# A303 Amesbury to Berwick Down

8.4 Statement of Common Ground – National Farmers Union

**A303 Amesbury to Berwick Down  
Development Consent Order 2019**

**STATEMENT OF COMMON GROUND –National Farmers Union**

Drawing Title
**RIGHTS OF WAY AND ACCESS PLANS
REGULATION 5(2)(k) & 5(2)(o)
SHEET 4 OF 15**

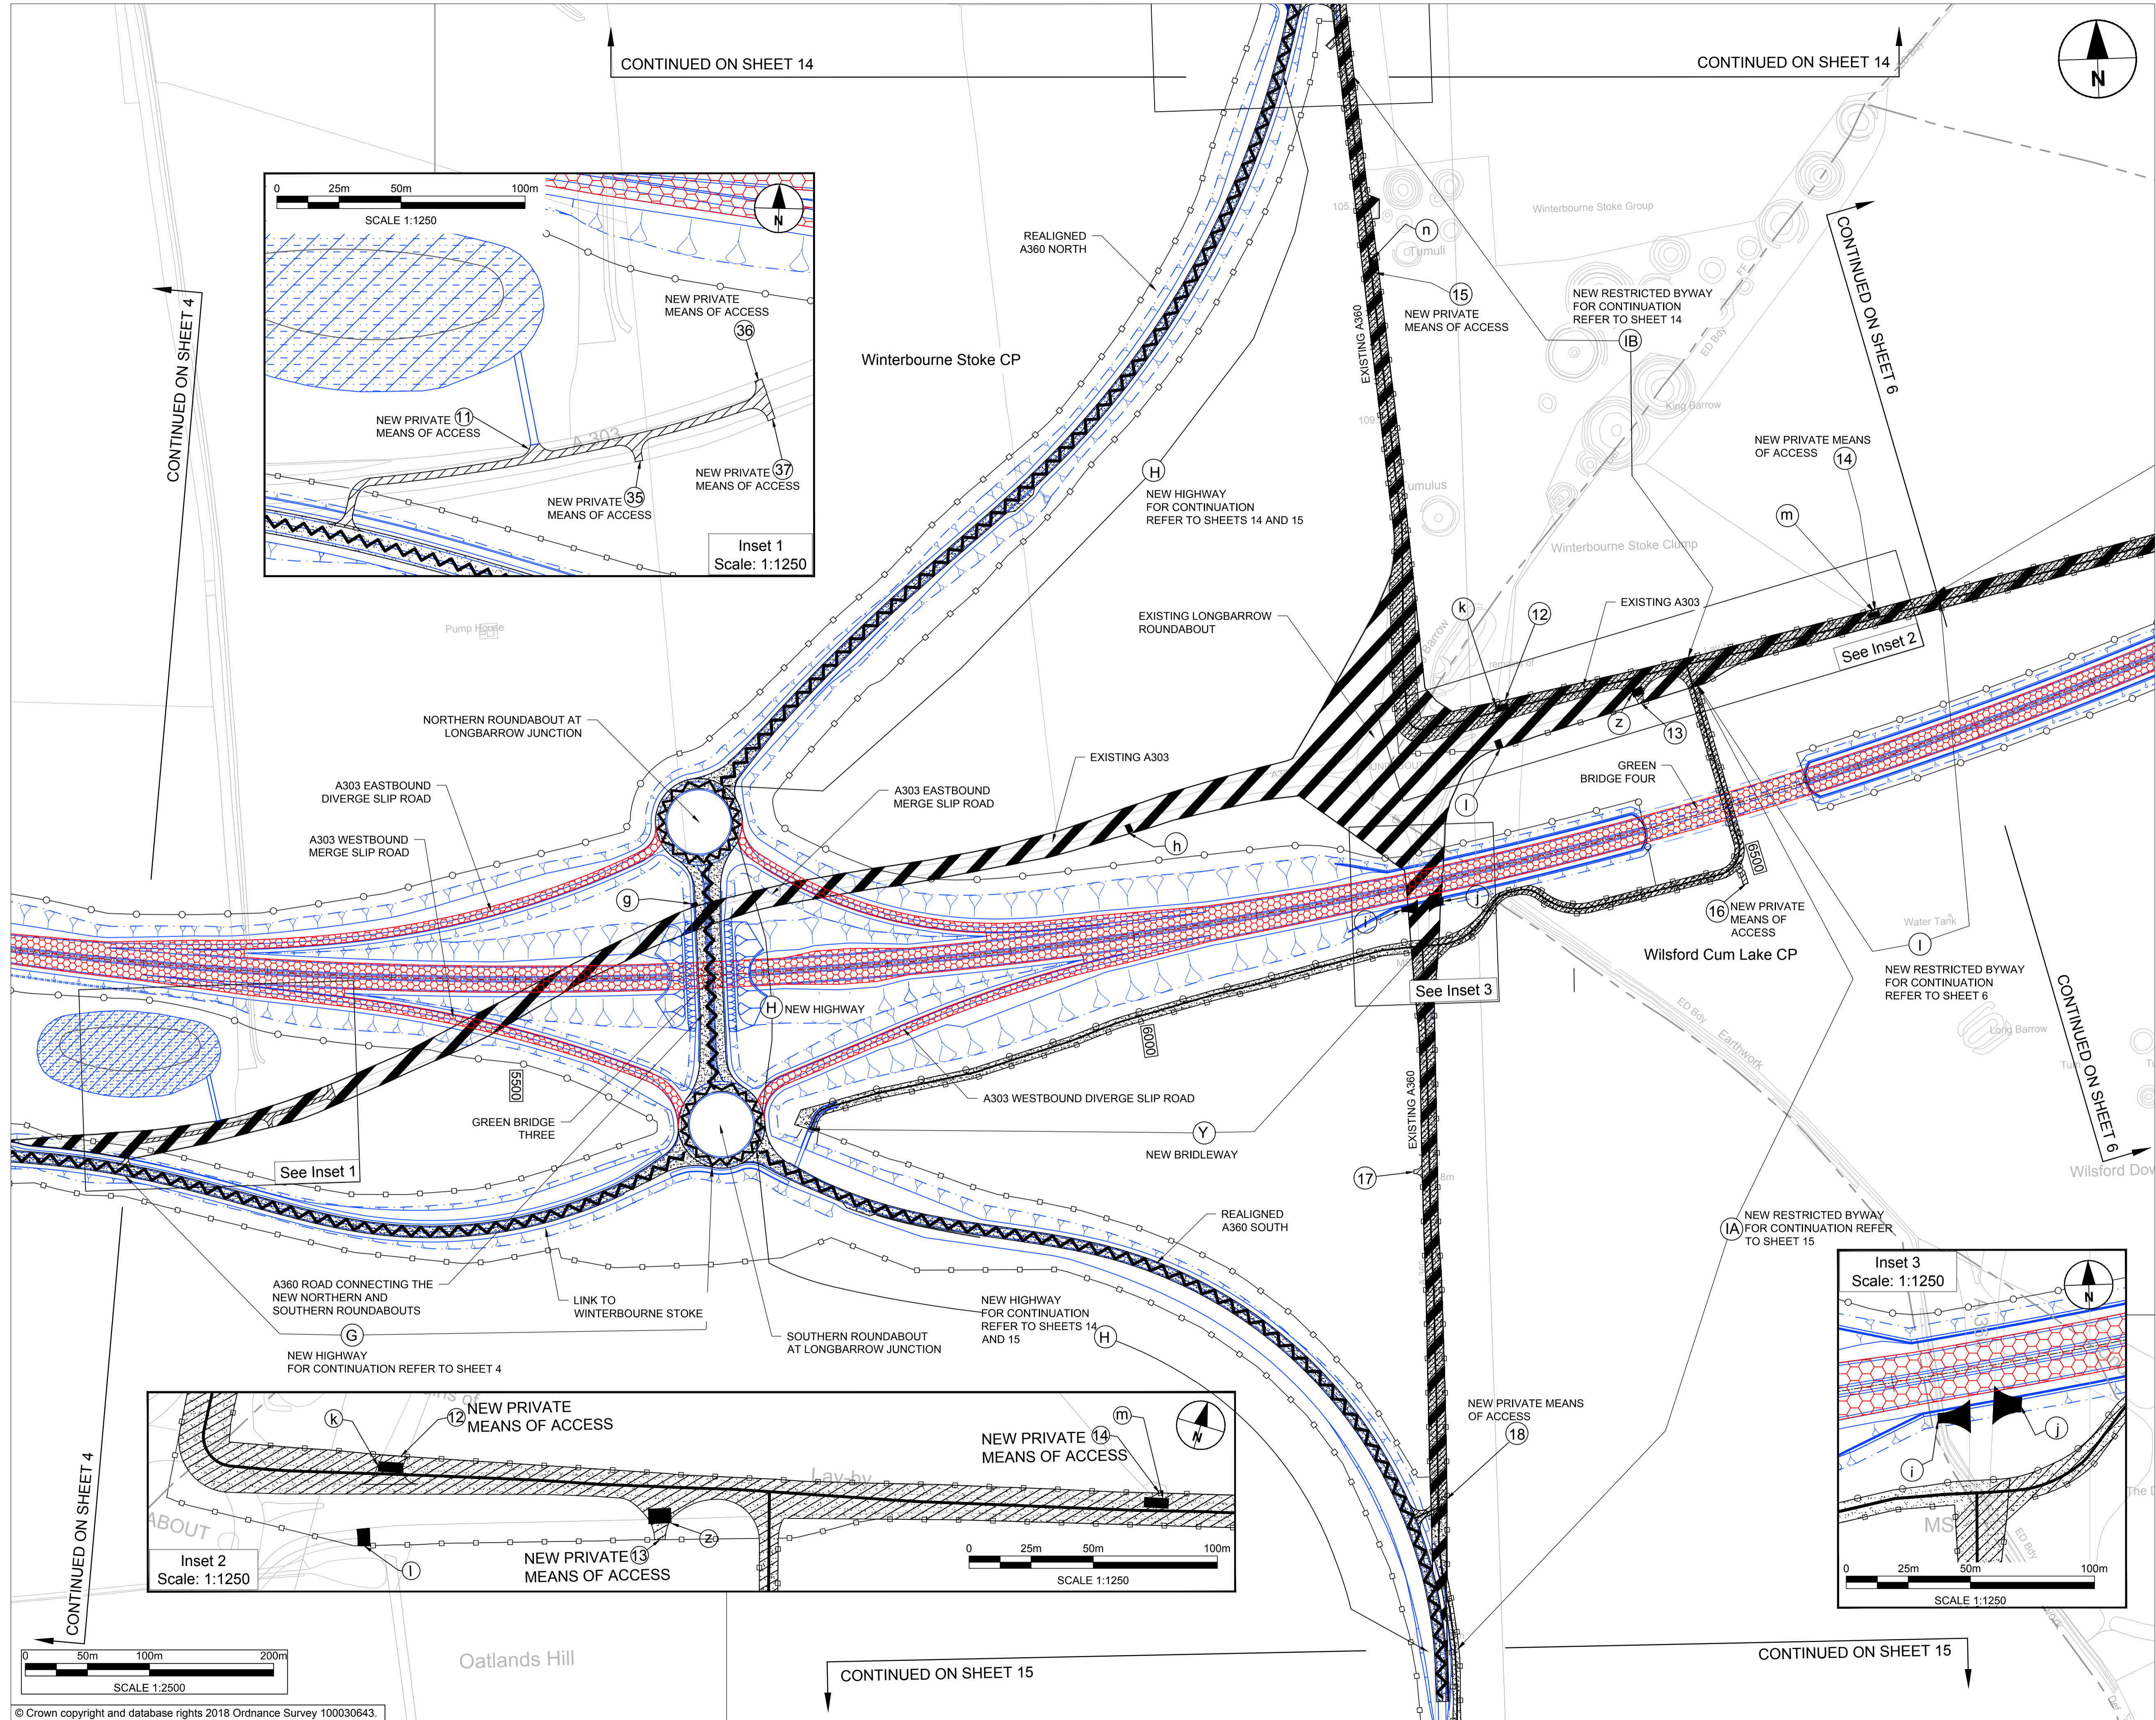
Plan, Appendix 2.2 of the ES (document reference 6.3), secured by requirement 4 in Schedule 2 to the draft DCO [APP-020].	
4.8	ES Chapter 11- Road drainage and the water environment [APP-049]	11.3 Assessment methodology (and Appendix 2.1)	11.3.10 – 11.3.13 Consultation	<p>Further information is needed in regard to the size and location of the drainage infiltration.</p> <p>Concern: The locations are greatly interfering with farm operations within fields.</p> <p>Solution: A new access route has been highlighted. This is not necessary and access could be created from the byway at green bridge no.2.</p>	<p>Following this consultation feedback, the number of drainage infiltration areas has been rationalised in terms of reducing the number from five to four and locating them closer to the new road. Due to the reduced number, each infiltration area needs to be slightly larger to meet the storage capacity requirement and to provide permanently wet areas to create dew ponds and allow for biodiversity enhancements. Access to the infiltration pond by Green Bridge 2 on the northern side of the A303 will now be accessed from the byway. Access to the pond on the southern side of the new road, by the viaduct, will be taken from a track within the field margin. The revised proposals can be seen within APP-009 2.6 Rights of way and access plans (sheet 4).</p>	UNDER DISCUSSION
